# **Glendruid Dolmen Public Group**

**Submission regarding Barrington Tower SHD**

**Application by Cairn Homes PLC**

**16<sup>th</sup> May 2022**

CGI View of Proposed Massing to South of the Site

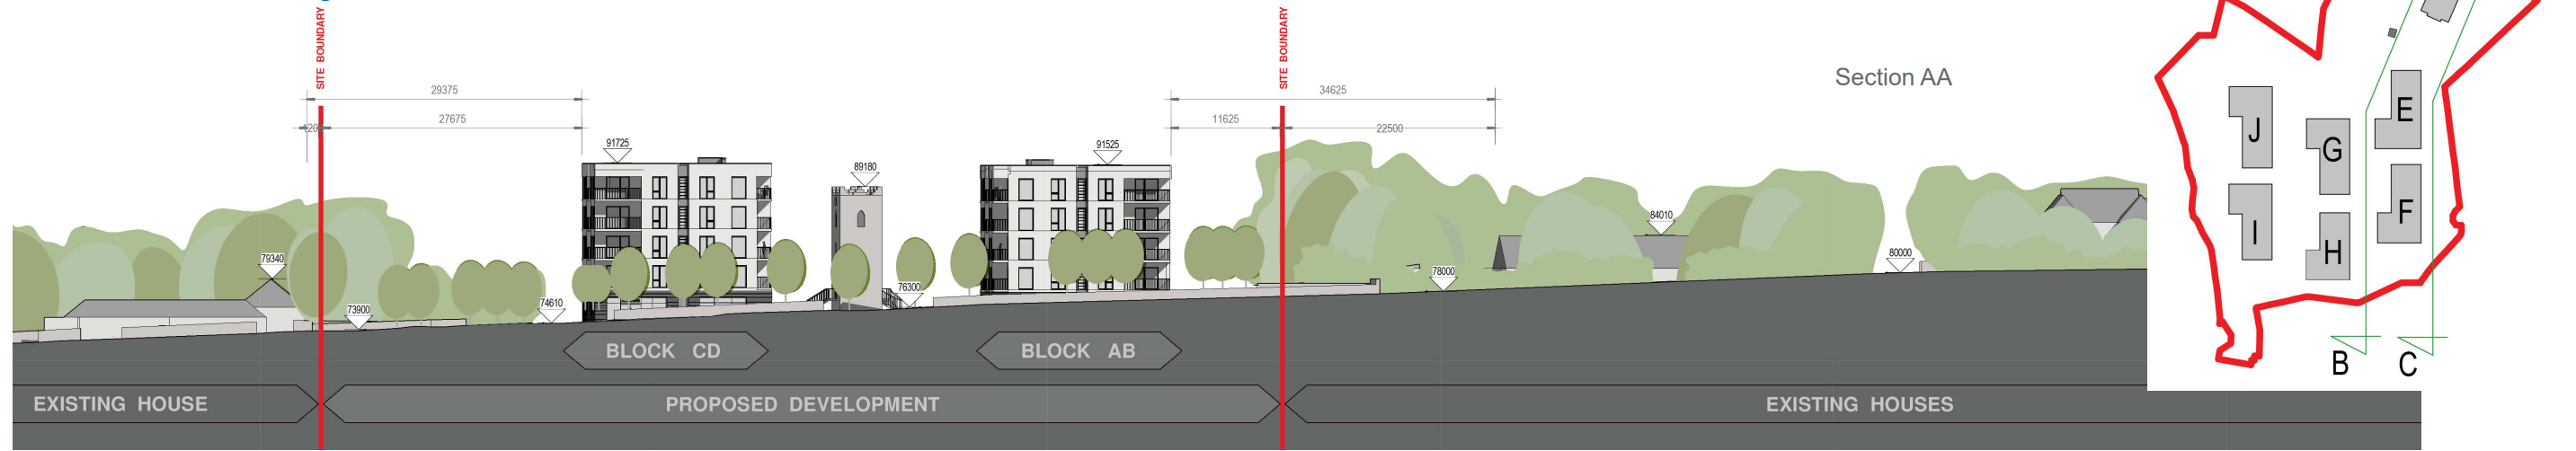
The applicant uses CGIs of a wholly positive framing perspective. The image below is used as a representative image for promotion of the development. This is misleading. The 5 storey buildings shown are higher than the tower and the 9 storey buildings to the right are omitted are not included. This selective framing is insufficient to evaluate the development application. Where are the view of the higher buildings and showing the minimum separations between buildings.

The application omits CGI showing the massing of the building on the site and the narrow space between buildings.
